WEST SUSSEX COUNTY COUNCIL CONSULTATION

TO:	Arun District Council FAO: Anita Gardner
FROM:	Highways, WSCC
DATE:	16 th July 2018
LOCATION:	8, Duncton Road, Rustington, BN16 3LA
SUBJECT:	R/134/18/PL 1 No. end of terrace two storey dwelling.
RECOMMENDATION:	ADVICE – MORE INFO
S106 CONTRIBUTION TOTAL:	£N/A

Drawing P01      May 2018      Scale 1:100 @ A3  
Planning Drawing - Site Plan & Floor Plans

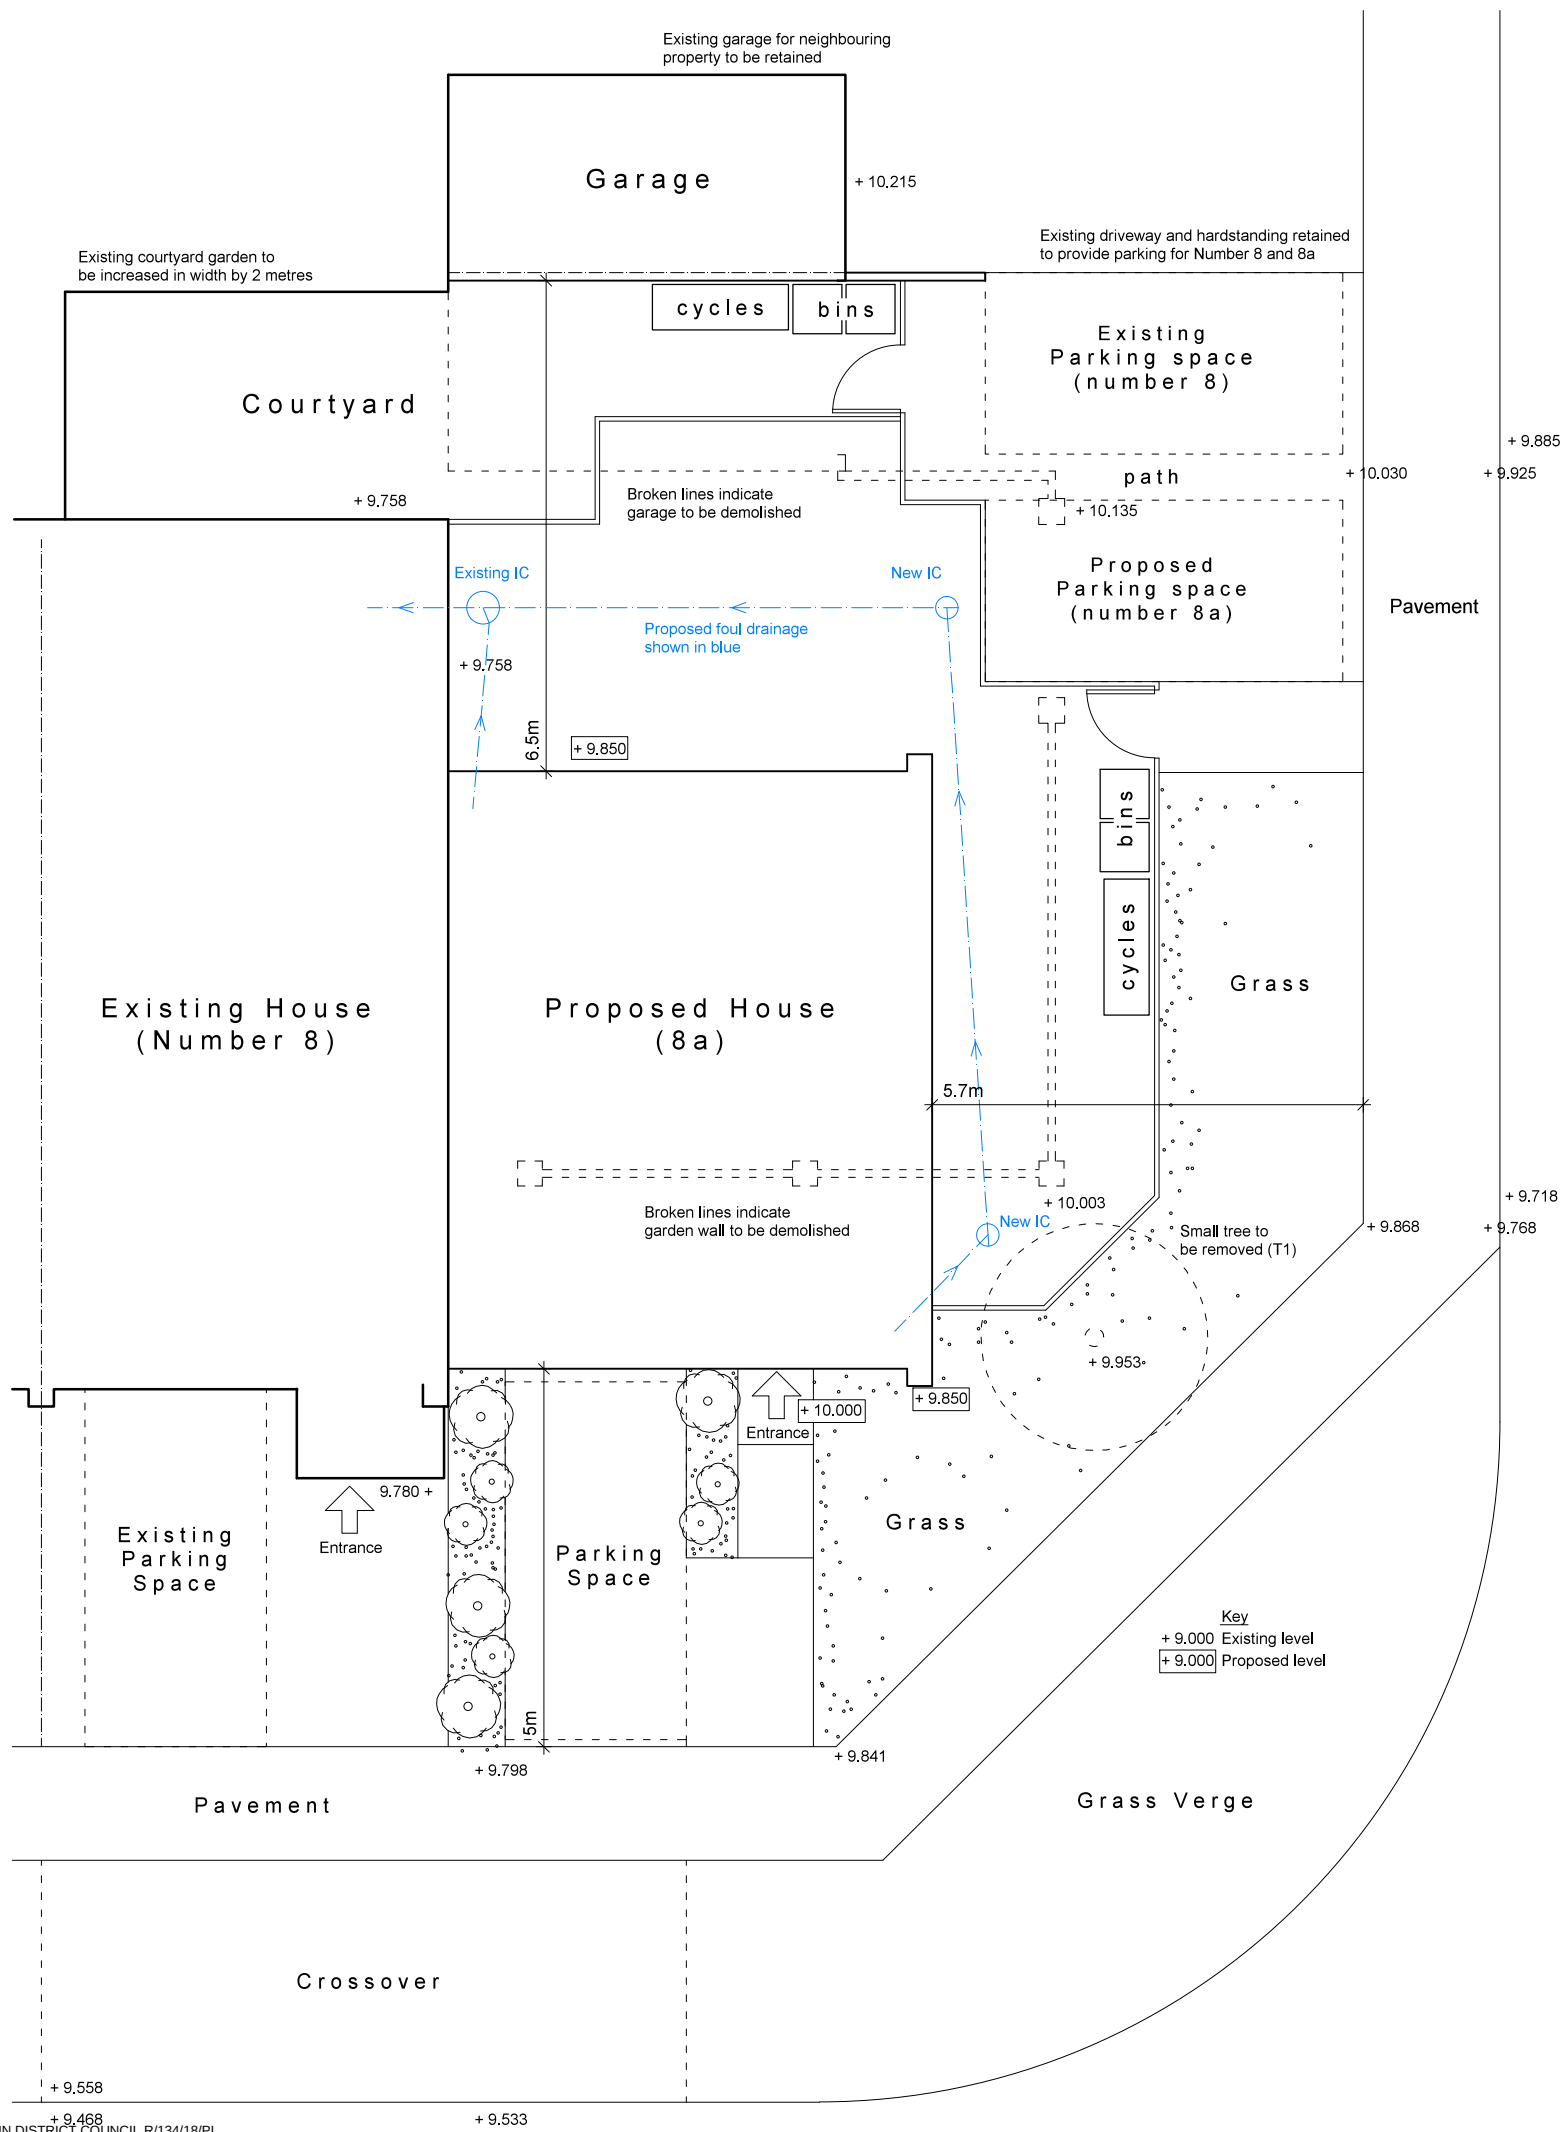
The garage to the rear will be demolished to provide an area for cycle and bin storage. The existing car parking space fronting this will remain for no. 8 Duncton Road. A proposed new parking space for the new dwelling is situated immediately west of this. It would appear that the existing dropped kerb along Bignor Close would require extending to accommodate this. The applicant should clarify the extent of dropped kerb works required on Bignor Close and mark this on the proposed Site Plan.

On the frontage of Duncton Road an existing and proposed off-street parking spaces are shown. From an inspection of the plan and WSCC mapping there appears to be insufficient depth on the frontage of no. 8 for the space marked 'existing'. Parking spaces should measure 2.4m by 4.8m to ensure a car does not overhang the footway. Furthermore, the kerb appears to not be dropped currently and thus

this 'existing' space cannot be in place. The proposed parking space on the frontage of the proposed dwelling is of sufficient depth due to the building set back. The applicant should demonstrate that sufficient depth is available for the space marked 'existing' or omit this from the plans (and reduce extent of proposed crossover).

- Mark the extent of crossover extension works required to Bignor Close (to provide access to proposed parking space for 8a).
- Demonstrate sufficient space for parking on frontage of existing dwelling or omit this from the proposed plans and amend extend of proposed crossover to Duncton Road.
